September 5, 2024

**RE: Martinez Retail Center**  
**1021 Old Coors SW**  
**Grading Plan**  
**Engineer's Stamp Date: 6/21/2024**  
**Hydrology File: L11D071**

Based upon the information provided in your submittal received 6/21/2024, the Grading & Drainage Plans **are not** approved for Grading Permit. The following comments need to be addressed for approval of the above referenced project:

GRADING PLAN

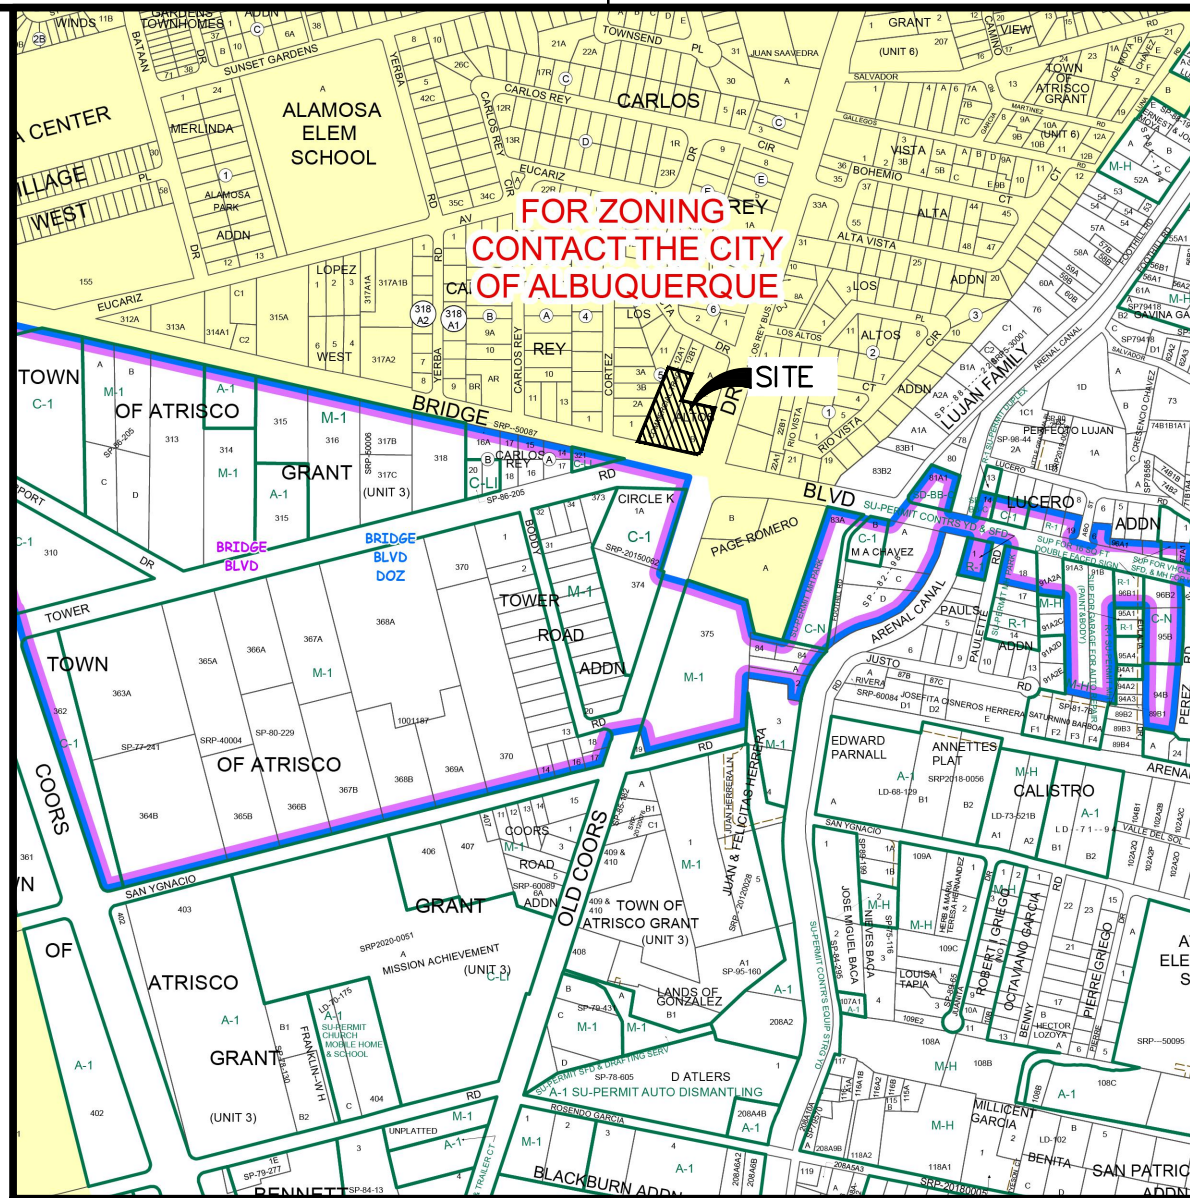
1. An SO-19 Permit will be required and should be included on the request. Please include the [standard SO-19](#) notes on the grading plan.

2. Stormwater discharges across the sidewalk are not allowed on collector roads and above; provide sidewalk culverts or drain lines through the curb for ponds 6, 7, and 8.
